Submission for Job: #6011 SSD 6011 - Mixed use residential development within the South West Plot

SSD 6011 - Mixed use residential development within the South West Plot

29 July 2013

LEVEL 6

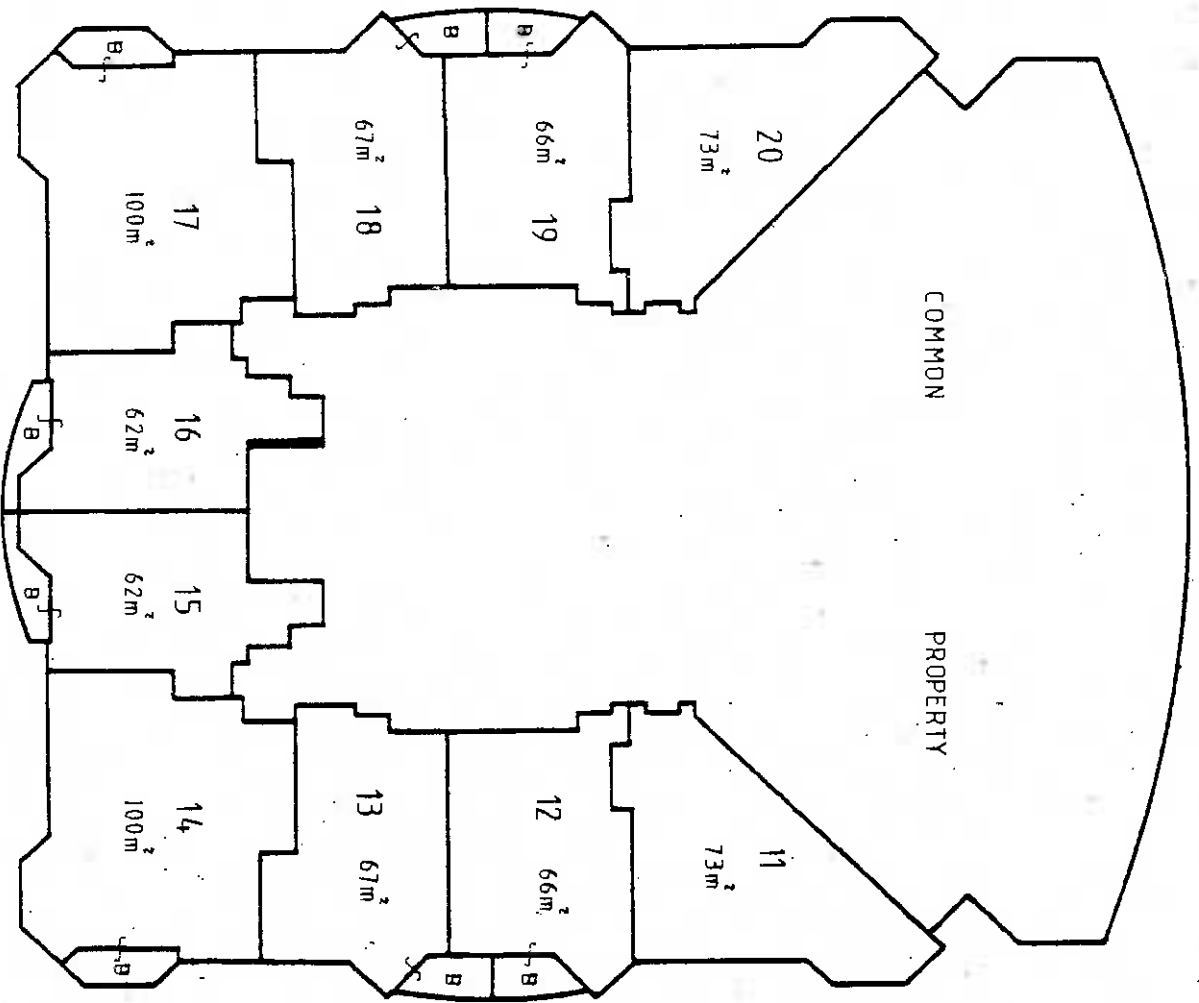
Levels 6 and 7 each contain two apartments with single west aspect , i.e. 4 single aspect apartments.

LEVEL 8

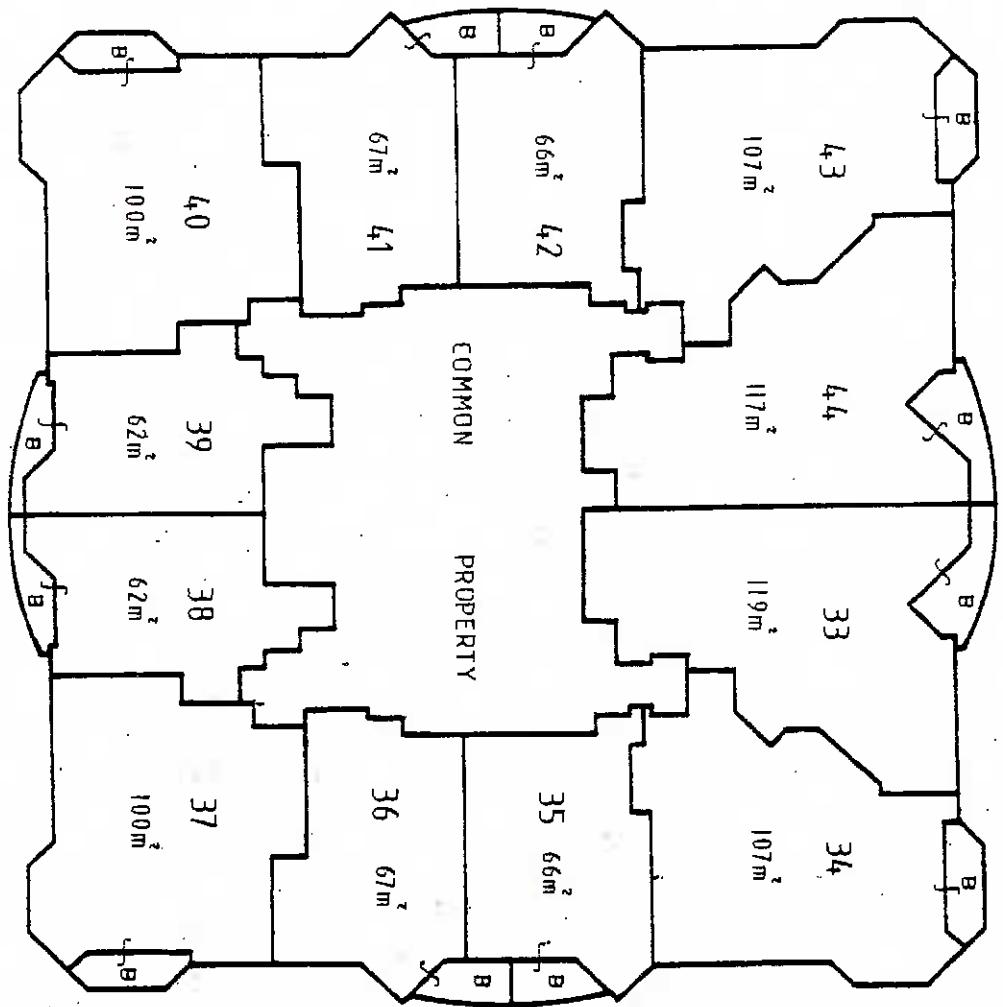
Levels 8-15 each contain two apartments with single west aspect and two apartments with single north aspect , i.e. 4 single aspect apartments per level, giving 32 single aspect apartments.
